**RE: Plaza Hacienda at Old Town Phase II**  
**Grading and Drainage Plan**  
**Stamp Date: 10/5/17**  
**Hydrology File: J13D037**

Based upon the information provided in your submittal received 10/6/17, the Grading and Drainage Plan **is not** approved for Building Permit. The following comments need to be addressed for approval of the above referenced project:

SHEET NO.
C-1

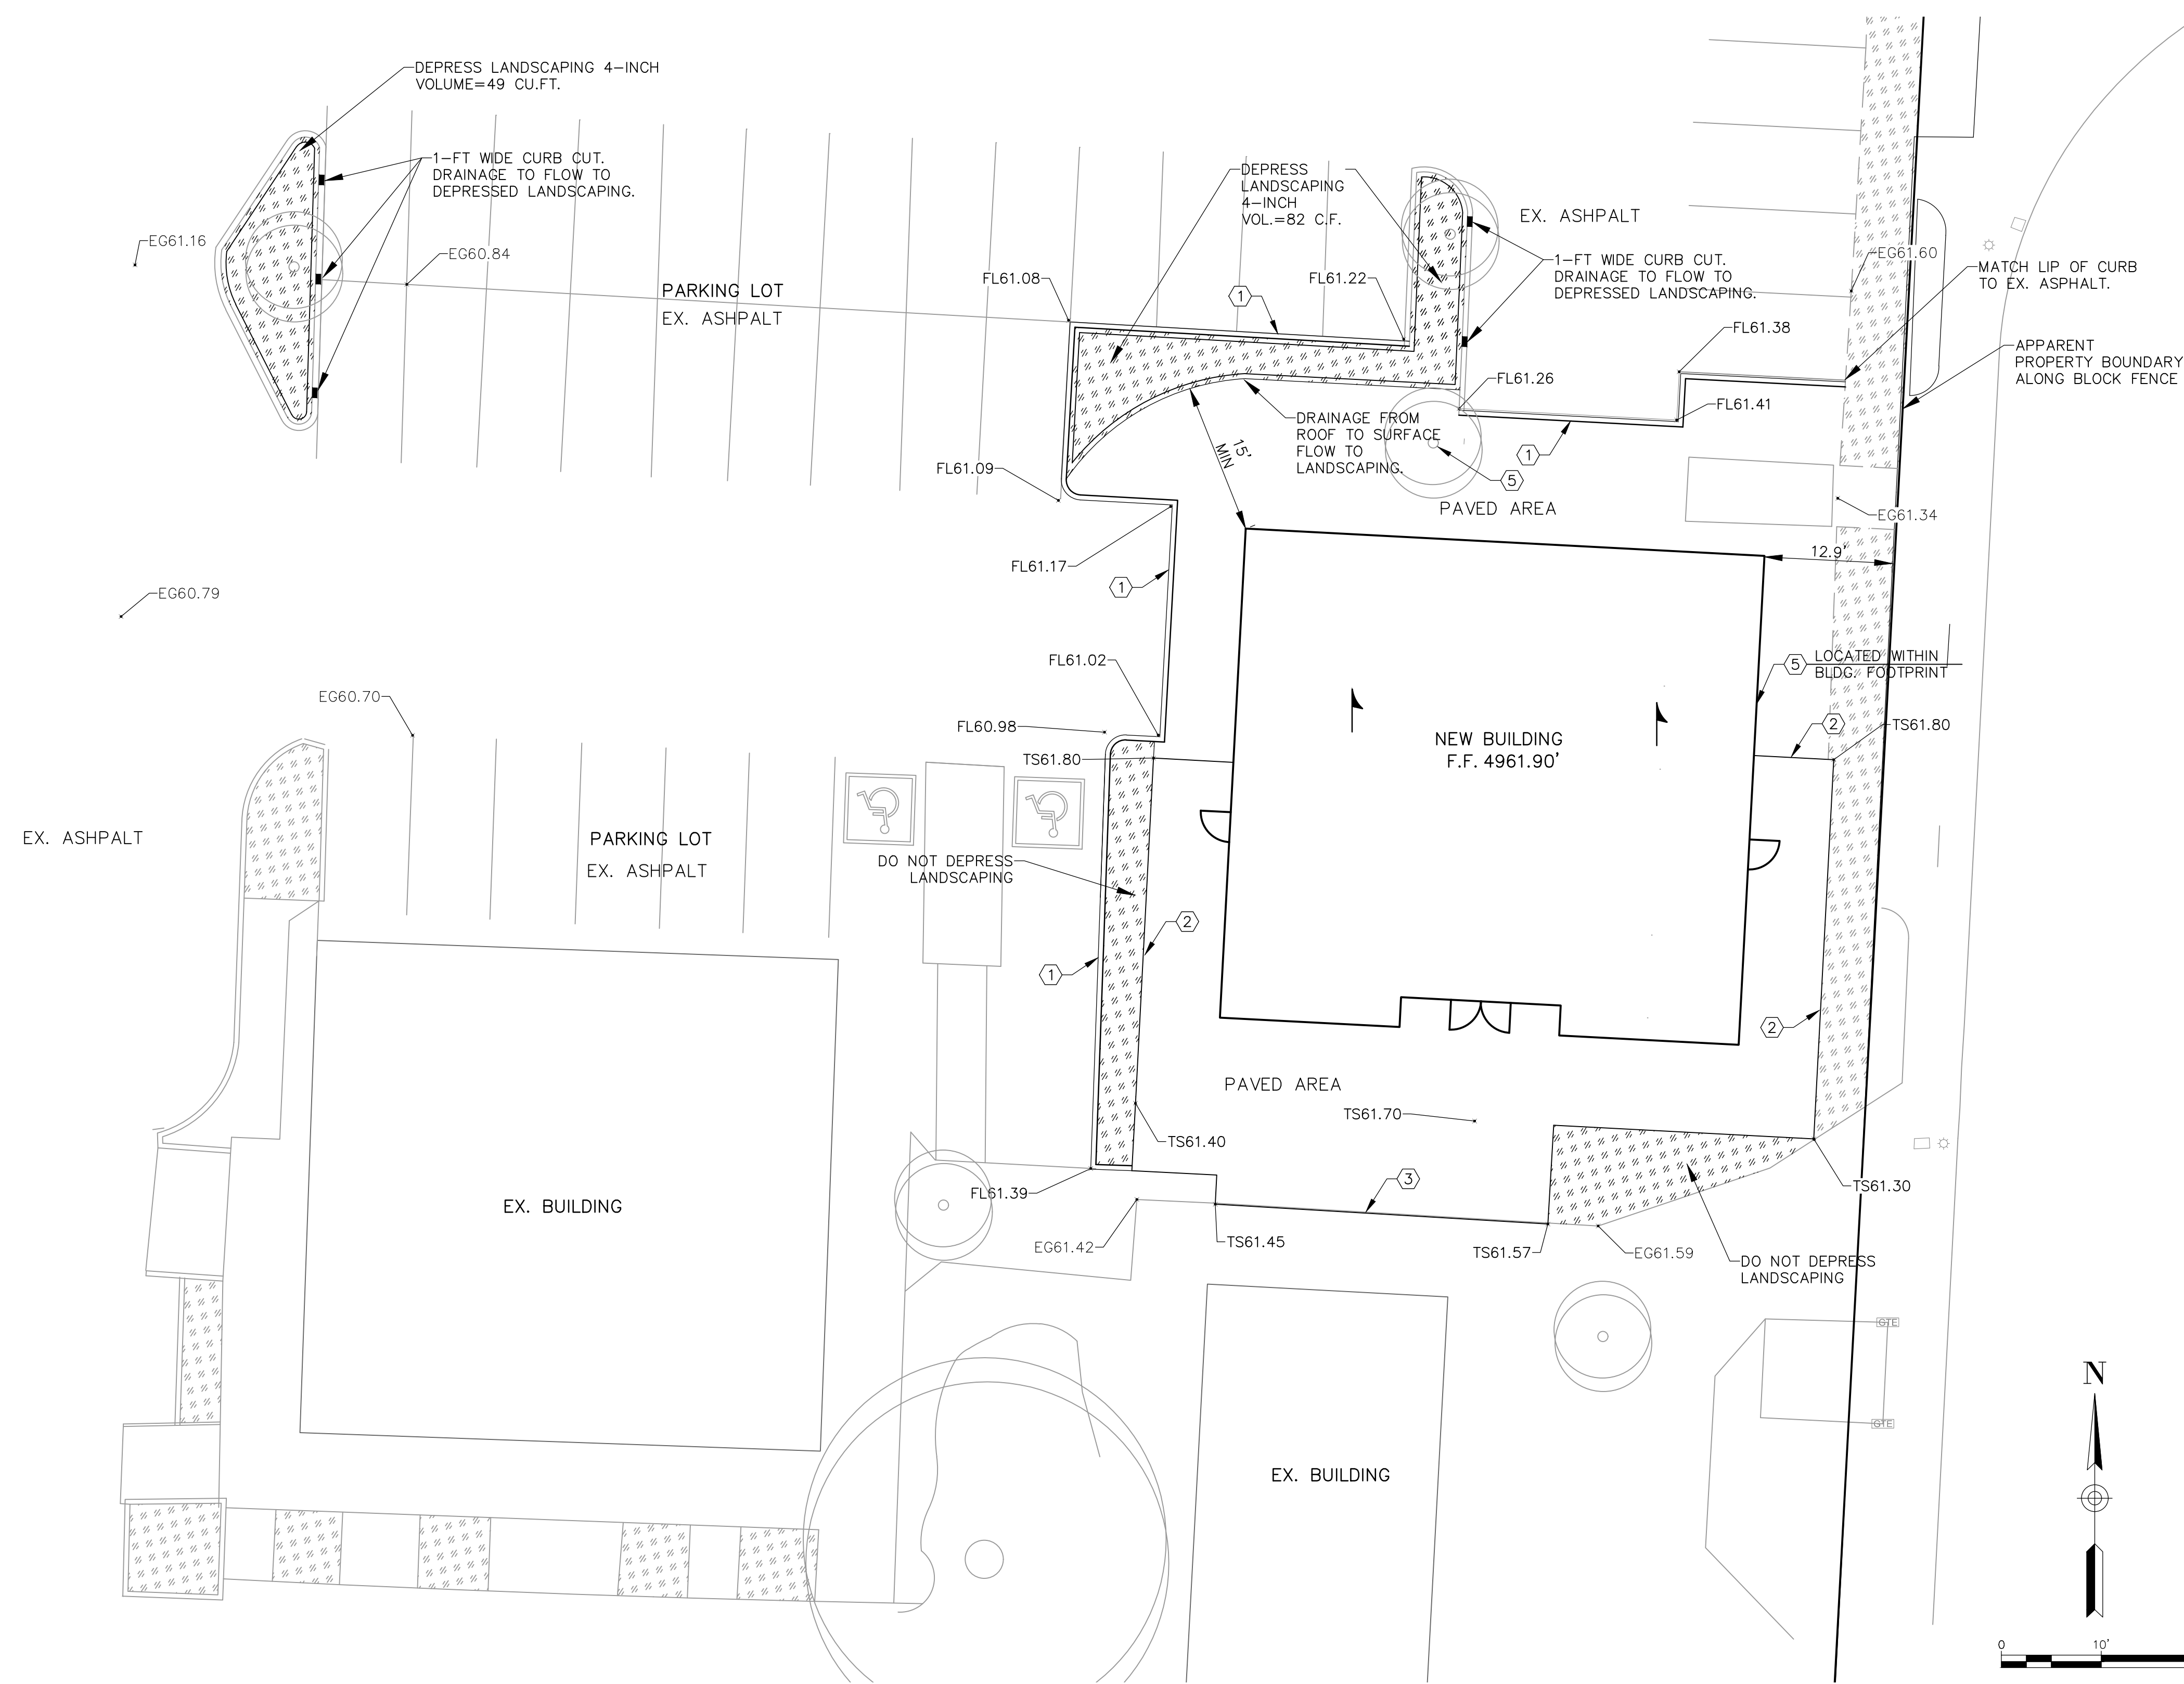
1. Sheet C-1. Please provide the benchmark information for the survey contour information provided.

2. Sheet C-1. For the first flush basins (the depressed landscape areas), please provide the volumes of each and indicate them on the Grading plan.

3. Sheet C-1. Please show how the drainage going into these basins.

4. Sheet C-1. Please show any roof drains if any and how they are to drain to the first flush basins.

5. Sheet C-1. There are currently several large trees on the site. Are these going to be removed or stay. Please show the trees w/ canopy and indicate if they are to be removed.

6. Sheet C-1. At the connection between the new curbing and the existing island curbing, there appears to be some of the existing curbing shown beyond the proposed curbing. Please clean up the drafting.

7. Sheet C-1. At the existing parking on the east side of the property, the proposed curbing stops at the parking strip. Shouldn't the proposed curbing continue to the edge of the existing parking lot? Also, is the existing asphalt going to stay between the proposed curbing and the proposed building? The existing parking stripping is still shown. Please clarify.
8. Sheet C-2. Under the Introduction, please fix the sq ft of the proposed bldg..
9. Sheet C-2. Under Existing Conditions, it states, "Refer to the grading & drainage plan on Sheet C-1 for the surface flows of the surrounding lots." There are not surface flows of the surrounding lots on Sheet C-1. Please provide them.
